MASTER DEVELOPMENT DRAINAGE PLAN

**CLAREMONT COMMERCIAL
SUBDIVISION FILING NO. 2**

A RESUBDIVISION OF TRACT OF

NOVEMBER 2019

MASTER DEVELOPMENT DRAINAGE PLAN

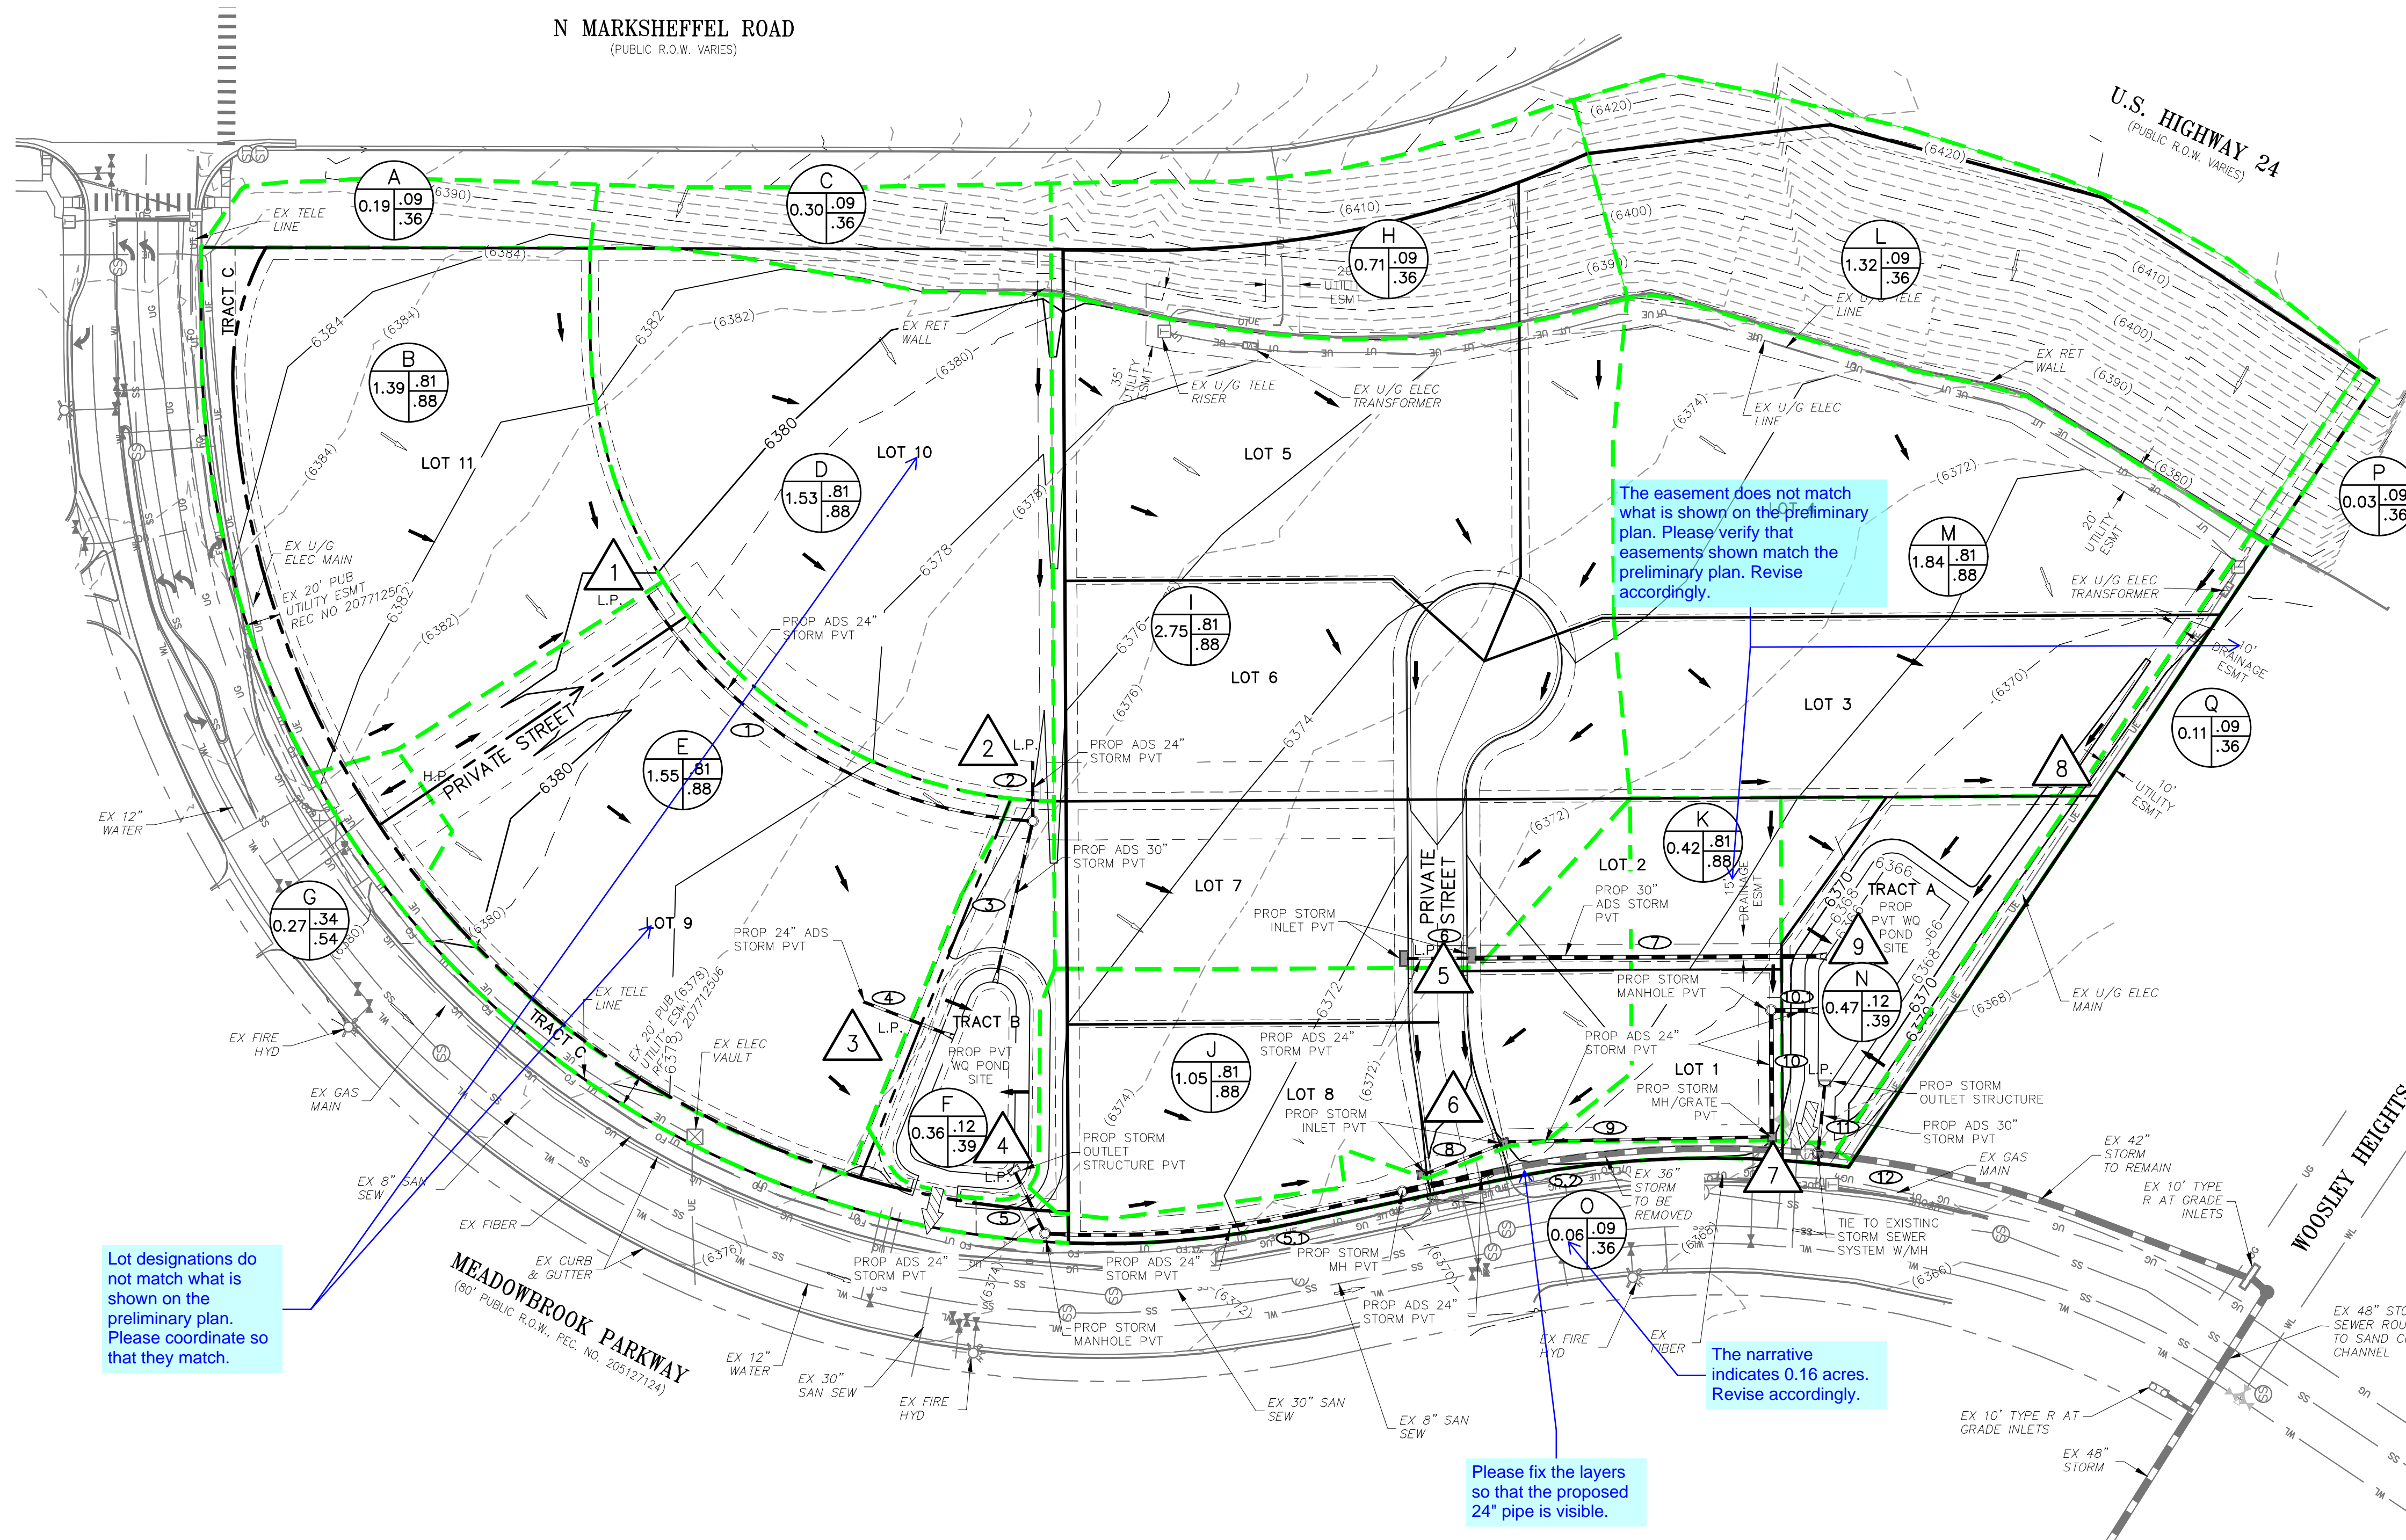
The acreage shown on the drainage plan does not match the narrative. Revise so that they match.

Include in your narrative a discussion regarding the swale shown between basin D and basin I.

Pipe 7 is indicated as 30" on the drainage plan. Revise accordingly.

revised

swale statement added

30" added
